25 June 2019

RMS Reference: SYD12/00236/17 and SYD17/00918/08  
DPE Ref: SSD 5175 MOD 4 and SSD 8588 MOD 2

**MODIFICATION TO THE EASTERN CREEK BUSINESS HUB  
ROOTY HILL ROAD SOUTH, ROOTY HILL**

STAGE 1 PROPOSED + AMENDED ROAD & CARPARK 1 : 500

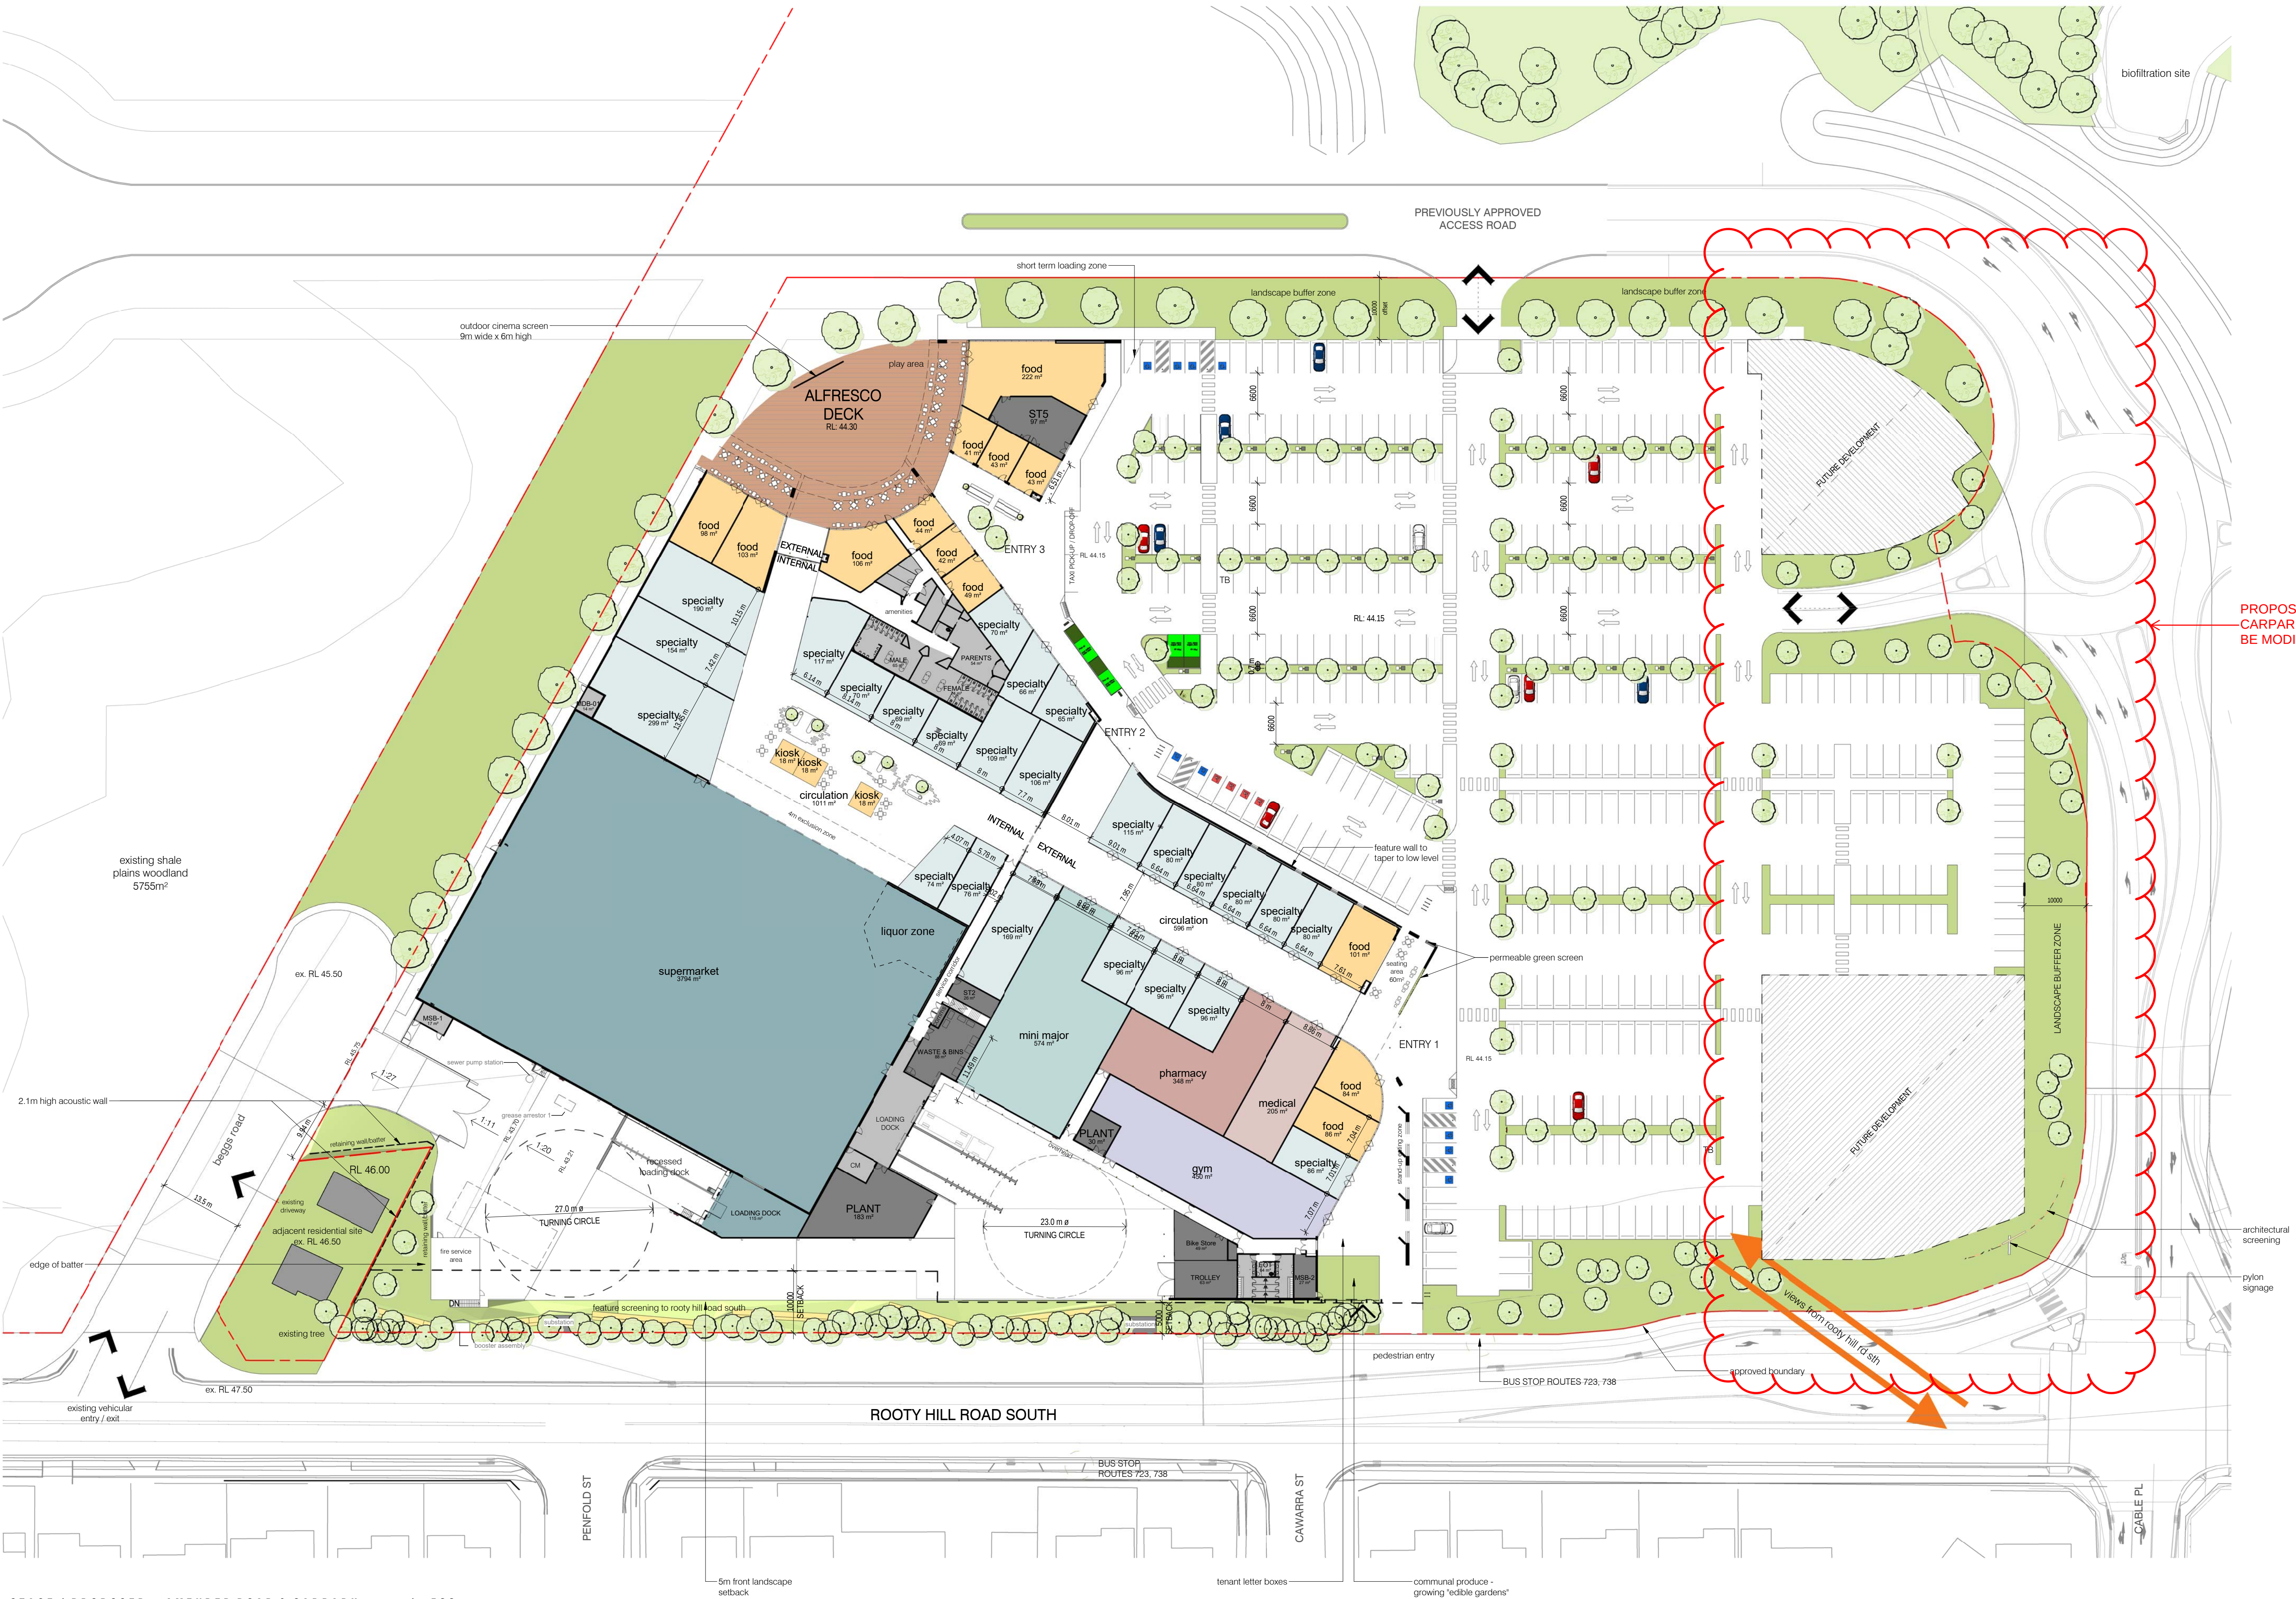
Roads and Maritime note that the design of the roundabout, in its current form may impact on the functioning of the Rooty Hill Road South / Cable Place intersection. However, Roads and Maritime would have no objections, in relation to the construction of a roundabout, providing that the access to Lot 2 from the proposed roundabout is modified from an entry/exit access to an exit only access arrangement. Amended plans reflecting the above modification are to be submitted to DPE for their review and approval.
